14625 Mill Haven Place, VR-18-005

Please accept the following comments from El Paso County Public Health for the plat amendment request referenced above:

# CATHEDRAL PINES SUBDIVISION FILING NO.2, LOT 51

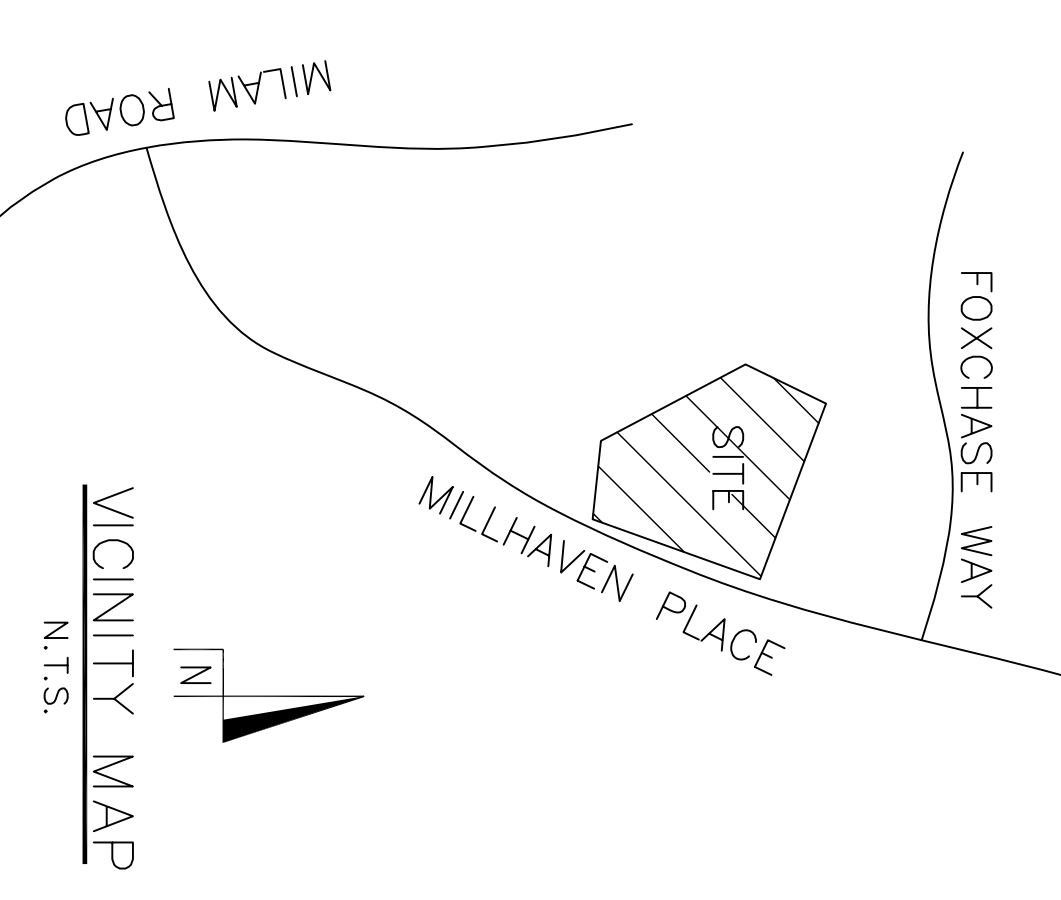
- **The primary and secondary OWTS soil treatment areas (STA) must be protected from all vehicular traffic or any activity that will subject the STA to compaction. Should the STA areas be compromised by compaction, then El Paso County Public Health will require the area(s) to be abandoned and new areas with associated soil testing be submitted and approved. The plot plan submitted shows the secondary STA on the opposite side of the No Build area of the house site, but the ENTECH Engineering Soils and Geology Report dated 06Apr2018 shows the secondary STA site adjacent to the primary STA. Please make sure El Paso County Public Health is made aware of the final secondary STA location.**
